CITY OF ALBUQUERQUE

February 1, 2023

**RE: Take 5 Car Wash
9601 Sage Rd. SW
Grading and Drainage Plans
Engineer's Stamp Date: No Date
Hydrology File: M09D035**

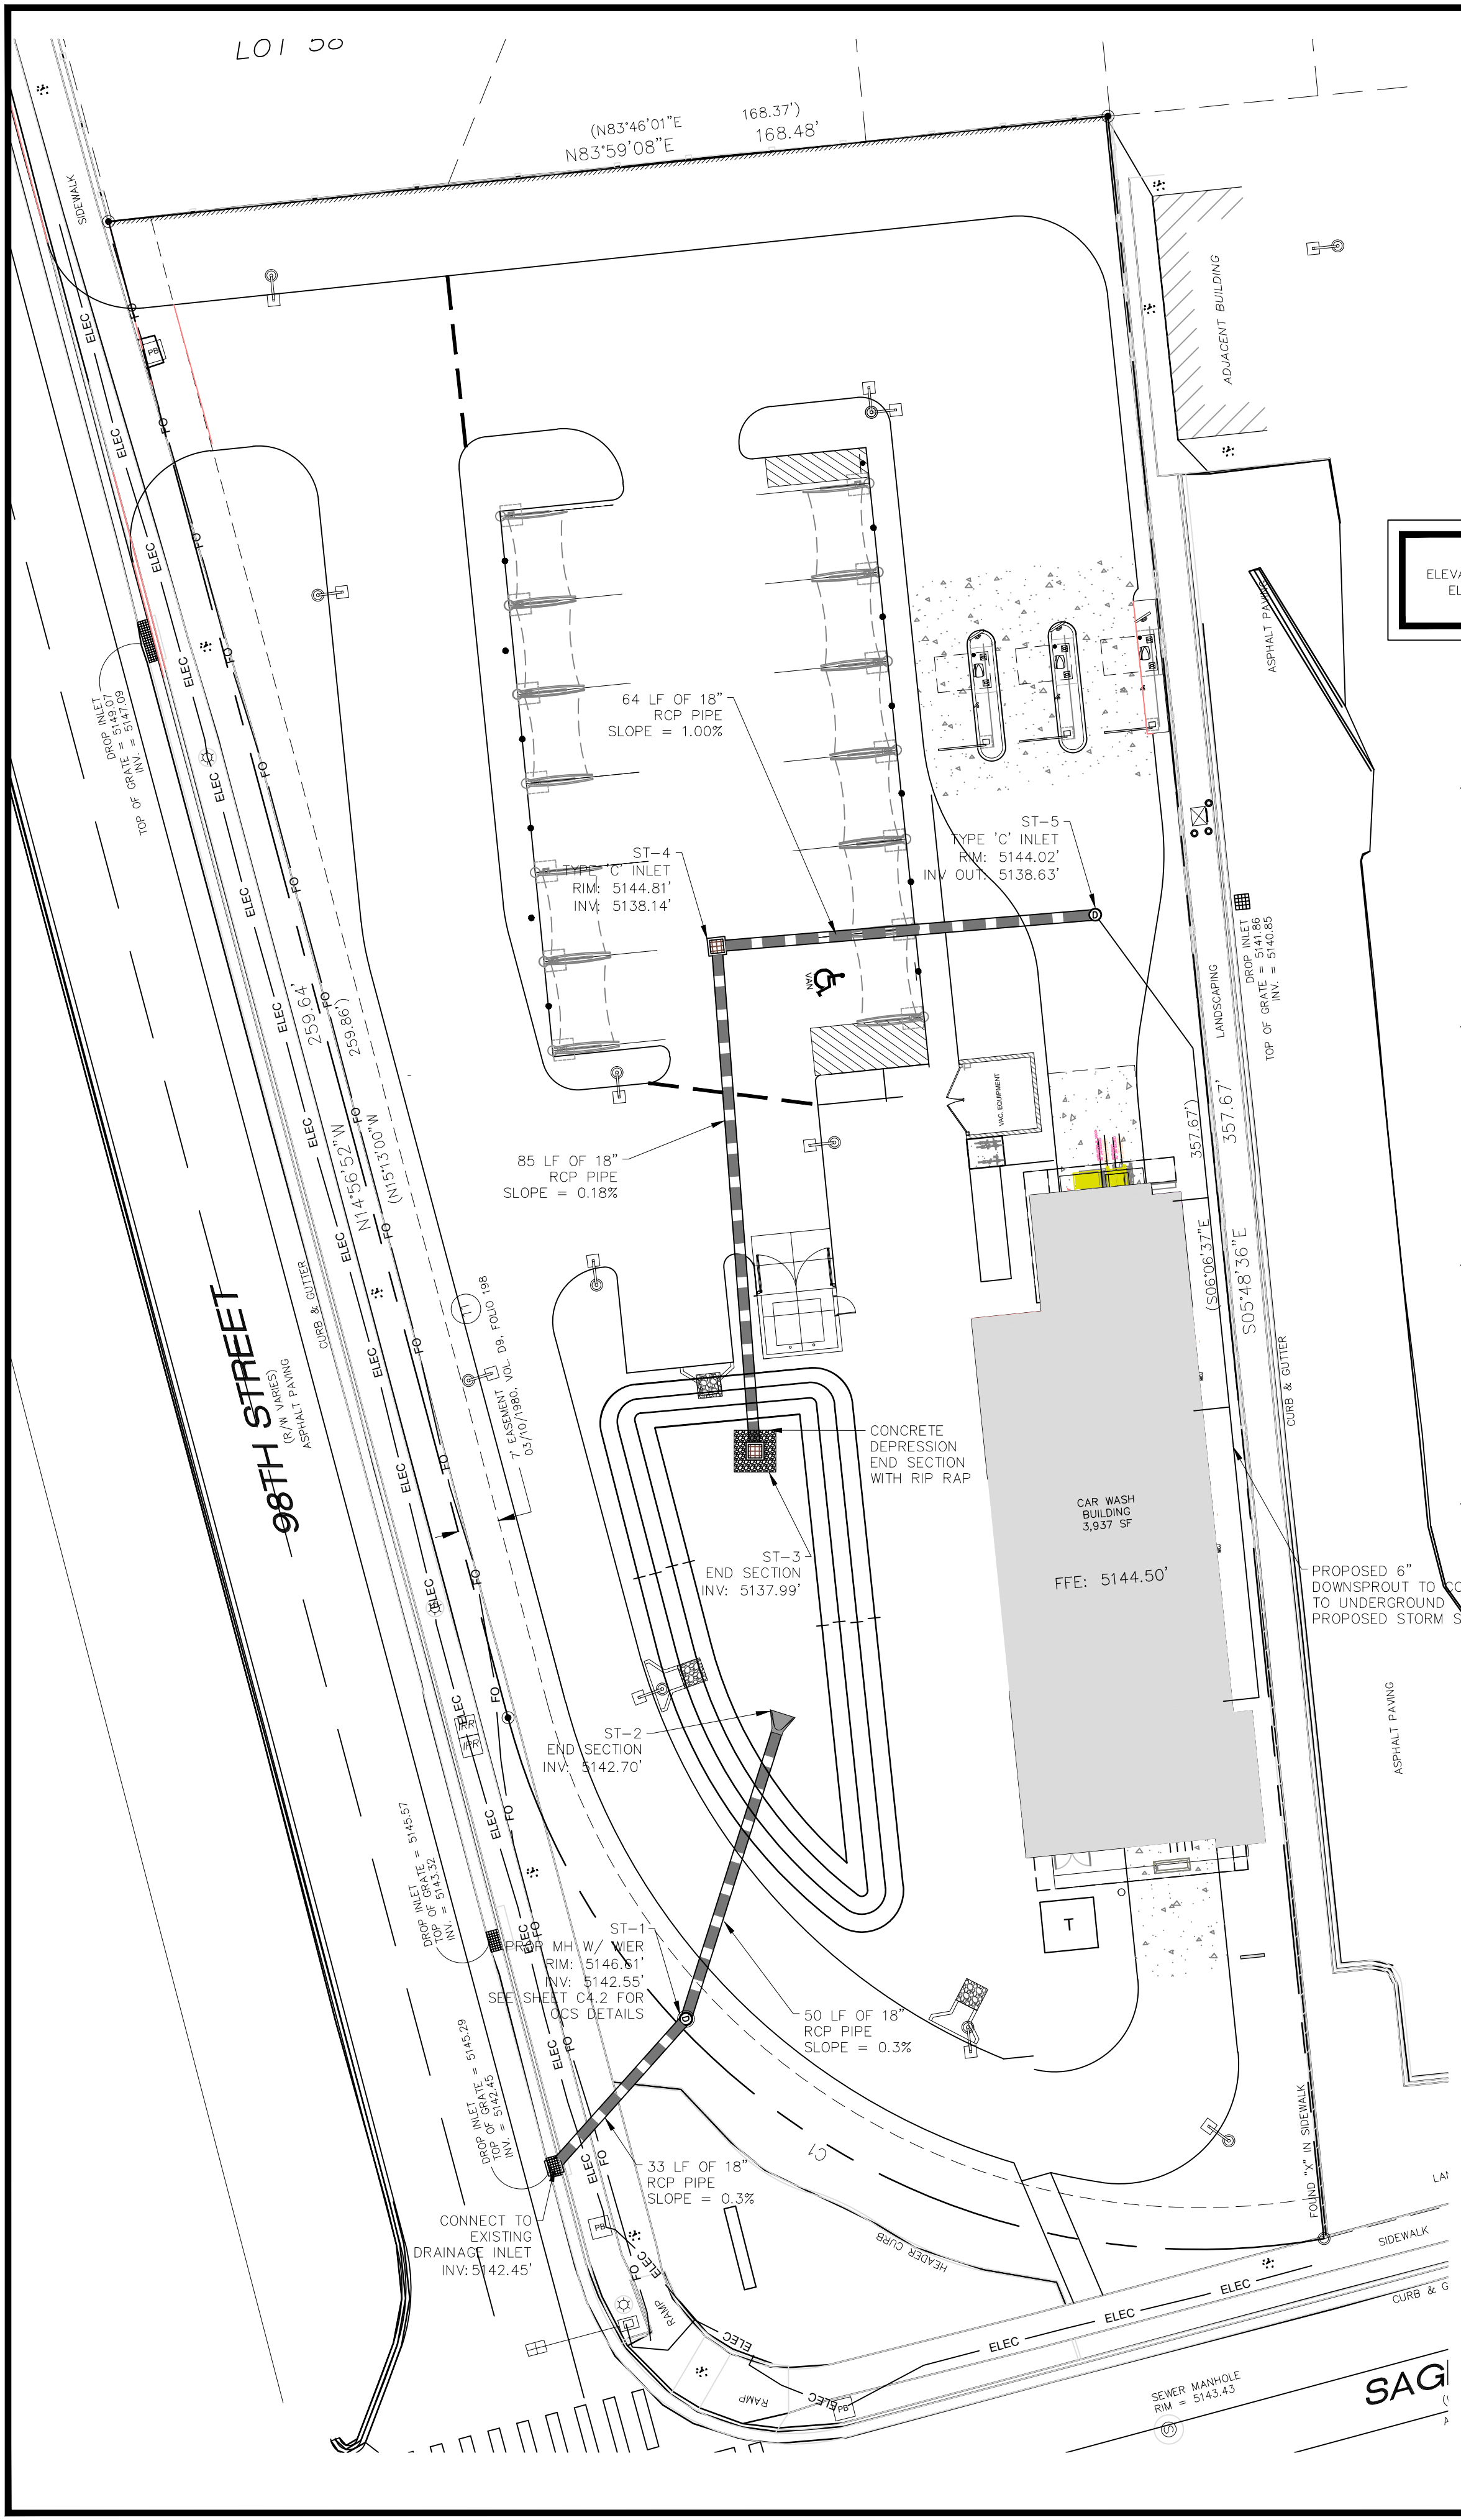
2. Per the DPM, the following must be on the Grading Plan. Please note the Grading Plan must be a stand-alone construction document.
 - a. Please provide an engineer's stamp **with a signature and date**.

- b. Please provide a Vicinity Map. Typically, this is the Zone Atlas. This can be downloaded in pdf format from the City of Albuquerque's website.
 - c. Please provide the Benchmark information (location, description and elevation) for the survey contour information provided. This is a City Benchmark that the surveyor should have pulled from.

- d. Please provide a legal Description of the property.
3. This site is within the Amole-Hubbell Drainage Master Plan. Specifically, it is in Drainage Area TS206. This site was to go into the existing detention pond TS2. However, after reviewing the design of this pond, there is no capacity for this development and connecting to the existing storm drain along 98th Street is not allowed. No increased runoff to overcapacity systems can be authorized per § 14-5-2-12 (G) of the Albuquerque Code of Ordinances. Therefore, this development will have to provide a

retention pond (100 year – 10 day volume) as outlined in Section 6-11(A)(2) Retention Ponds in the DPM. Please note that the required SWQ requirement is within this retention pond volume.

4. Please provide an emergency spillway for the retention pond. This spillway can be a sidewalk culvert at the retention pond water surface elevation at the pond and the existing gutter elevation on Sage Road.

5. Please provide a cross section for the retention pond showing the top of pond, bottom of pond, and the required retention water surface elevation. Please make sure that there is a one-foot freeboard. Add a note, "Side slopes need to be stabilized with Native Grass Seed (per City Spec 1012) with Aggregate Mulch or equal (Must satisfy the "Final Stabilization criteria" CGP 2.2.14.b.)".

8. A SO-19 Permit will be required for the sidewalk culvert. Please include the standard SO-19 notes on the grading plan.

DESIGN REVIEW COMMITTEE	CITY ENGINEER APPROVAL	ZONE MAP NO. Z-99
		CITY PROJECT NO. 000000
		SHEET NO. C-4.1

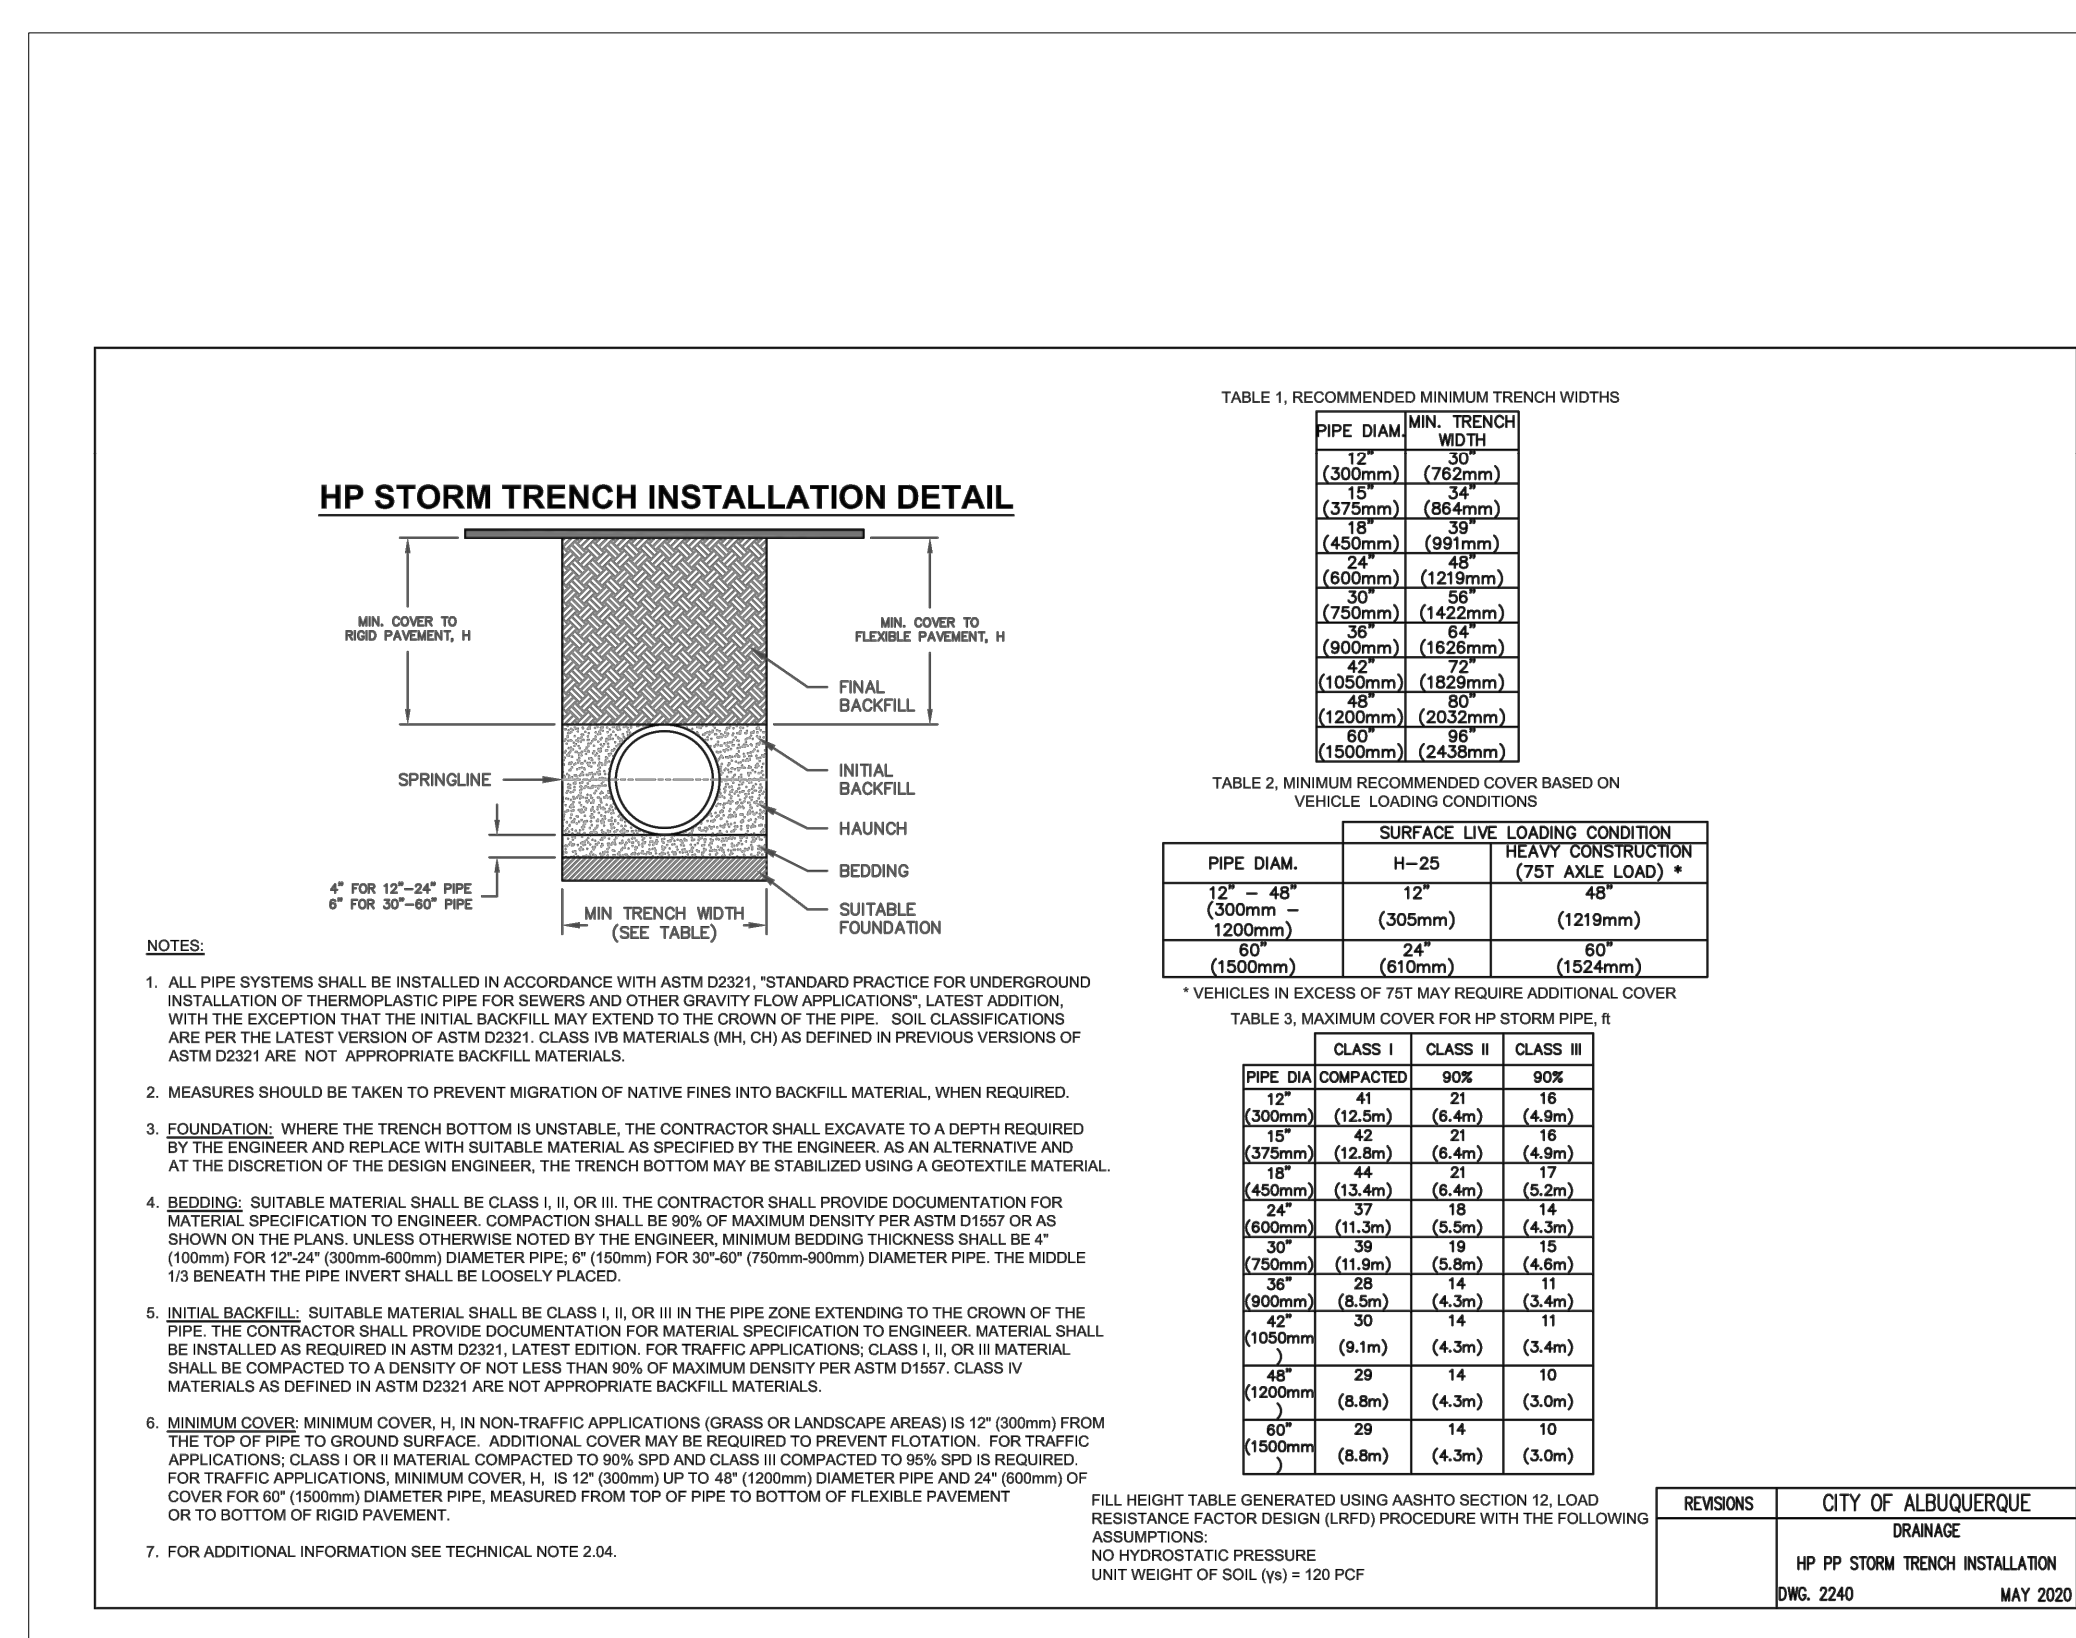
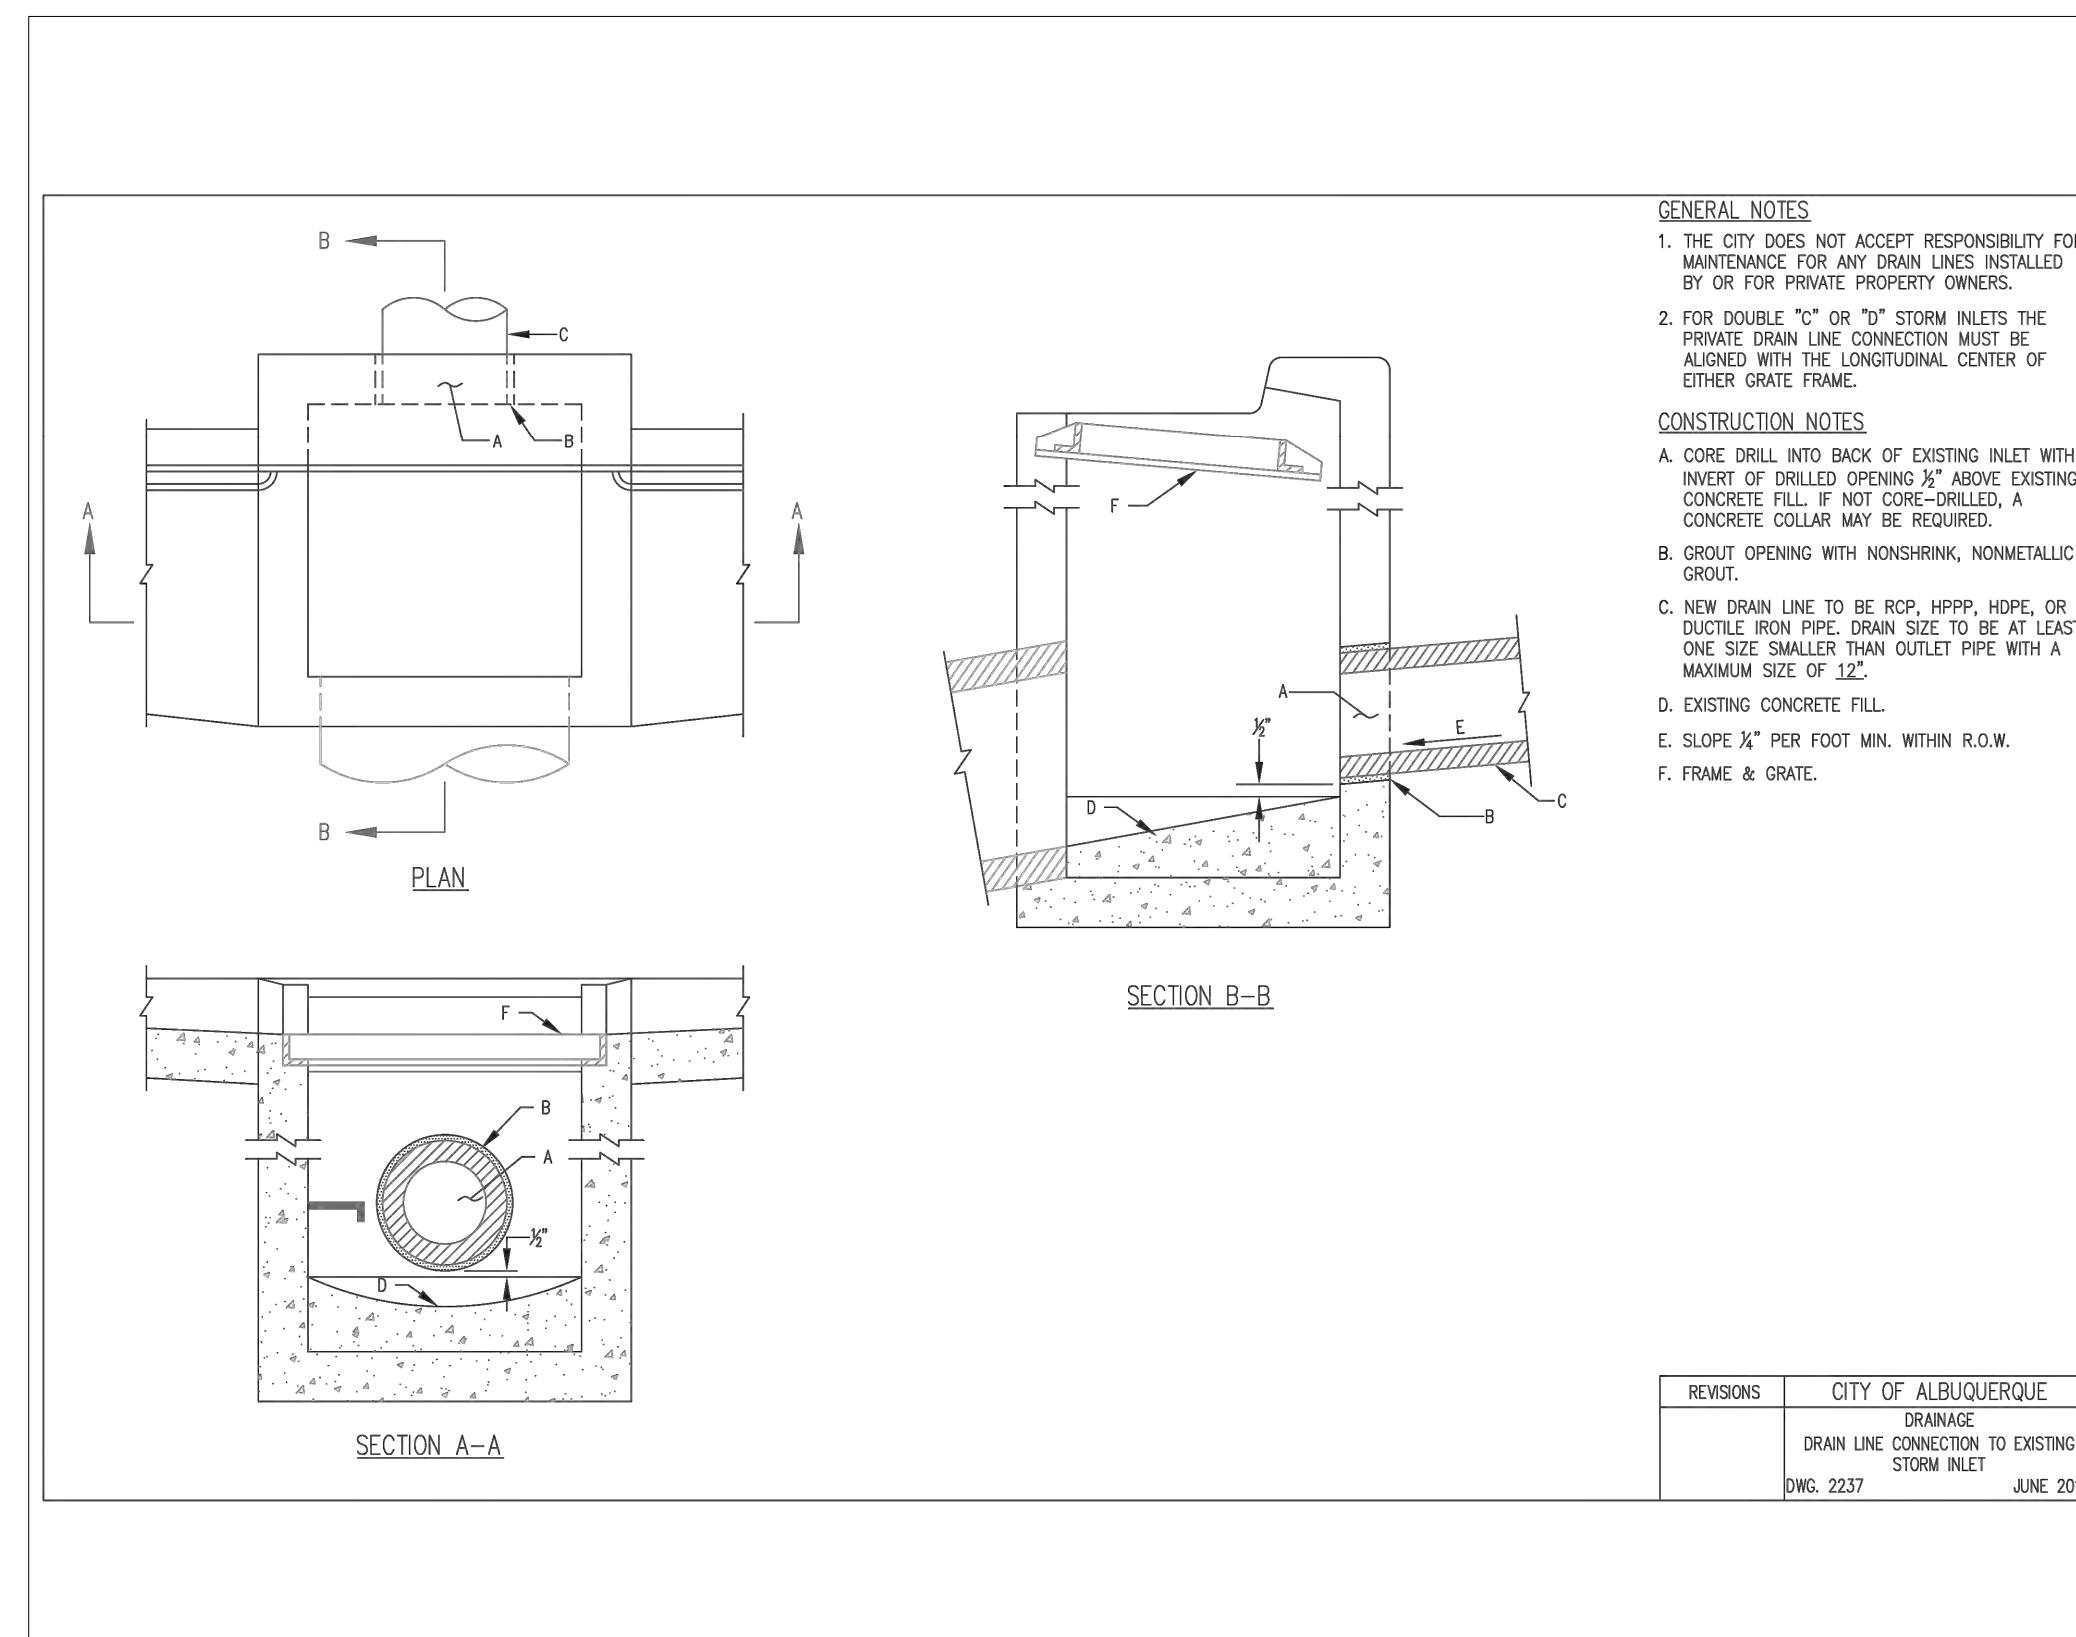
6. Please add the volume provided under the Stormwater Quality Calculations.
7. Please reference City of Albuquerque standard detail No. 2236 – Sidewalk Culvert with Steel Plate Top at the sidewalk culvert. Also, please provide the weir calculations, per DPM Article 6-16(A), for the curb cuts and sidewalk culverts. A coefficient of 2.7 is typically used for the weir equation $Q = CLH^{2/3}$.

9. Please use the procedure for 40 acre and smaller basins as outlined in Development Process Manual (DPM) Article 6-2(a). Please provide both the existing conditions and proposed conditions for the 100 year-6 hour storm event. These calculations should be on the Drainage Plan.
10. It appears that the proposed asphalt for the car wash and the proposed building is only about three feet from the existing three feet retaining wall (not structurally designed). Is there any proposed safety here such as adding a garden block wall so that vehicles do not drive over this onto the adjacent property which is below?
